From: Liz Annalls [REDACTED]
Sent: 02 March 2022 10:40
To: Planning.Responses <Planning.Responses@arun.gov.uk>
Subject: RE: Planning Consultation on: BN/14/22/PL

Application No: BN/14/22/PL
Site Address: Land rear of Cedar End Eastergate Lane Eastergate PO20 3SJ
Description of Works: 1 No. 5 bed detached bungalow with new vehicular access. This application is within CIL Zone 3 and is CIL liable as new dwelling.

Photo 7: B2, a shed

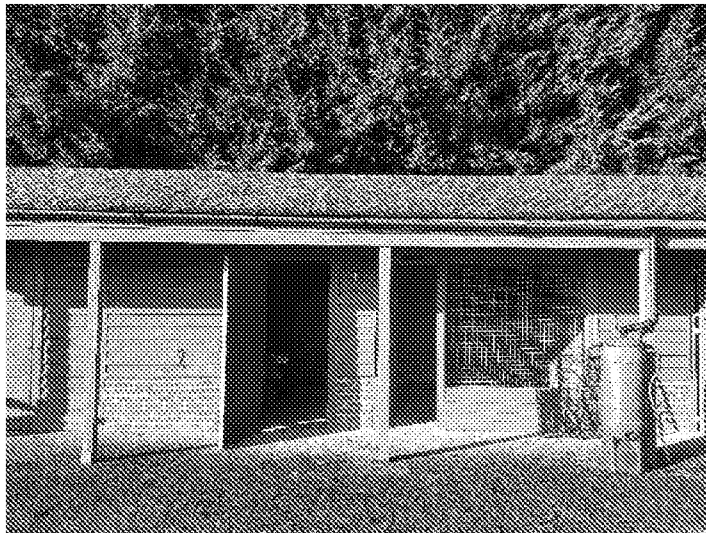
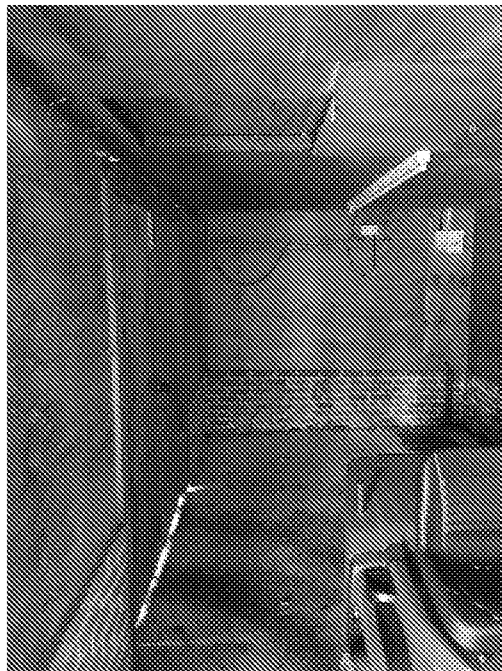
As detailed within the PEA (Jan 2022) there is potential for bats to be roosting within the building B2 on site. Due to this and as recommend within the survey further bat emergence surveys are required to determine if bats are roosting onsite prior to determination. This survey needs to be undertaken by a suitably qualified ecologist during the active breeding period (May – September) and submitted for our approval with the planning application. If bats are found to be roosting within the building mitigation will be required and a mitigation strategy should be produced and submitted with the planning application prior to determination.
